Ribble Valley Borough Council
Housing & Development Control

Application no: **3/2021/0190**

Address: **2 Water Meadows Longridge PR3 3BW**

Proposal: **Proposed single storey rear lean-to extension to form new integral garage. Conversion of existing garage to form new office/snug. Flat room link extension (side/rear elevation)**

PROPOSED GROUND FLOOR PLAN

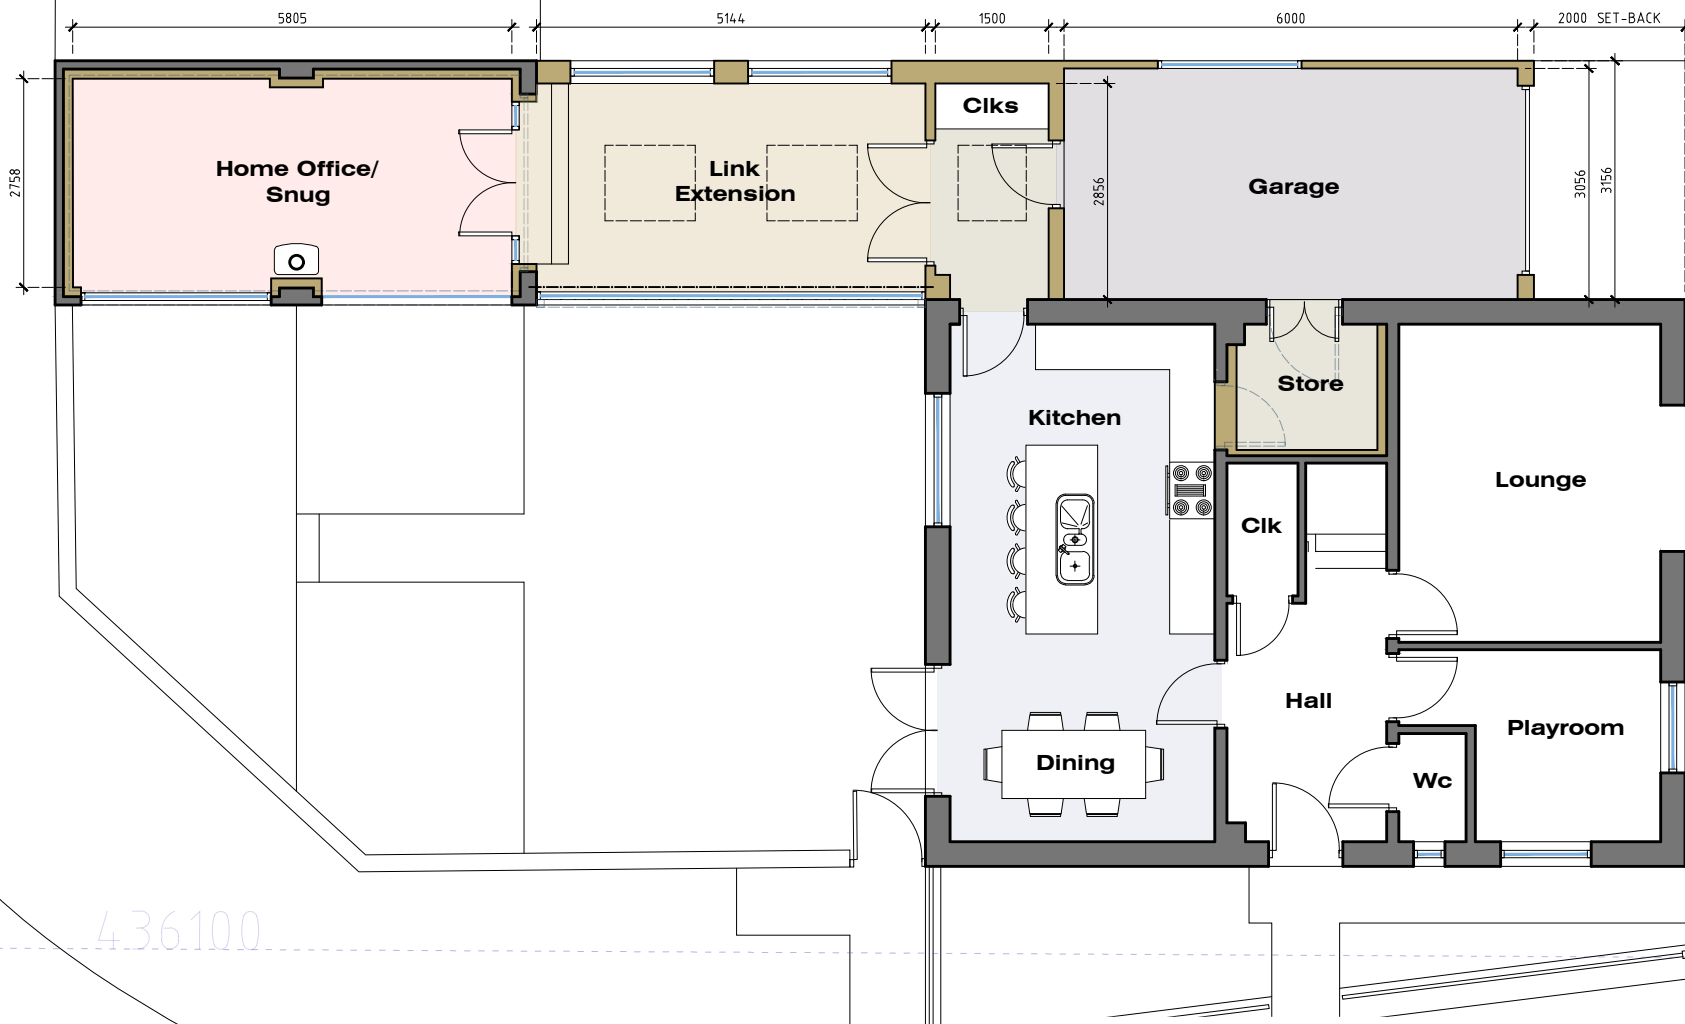
The proposed extensions and alterations will involve a reconfiguration of the existing parking arrangements and whilst the local highway authority would raise no objection to the principle of the development proposal, the proposed parking arrangements would not be considered satisfactory. The proposal will involve removing the shared provision of turning area for the shared access road, preventing vehicles from being able to enter and leave in a forward gear. The local highway authority therefore requests the plans are revised after further consideration has been given to the proposal.
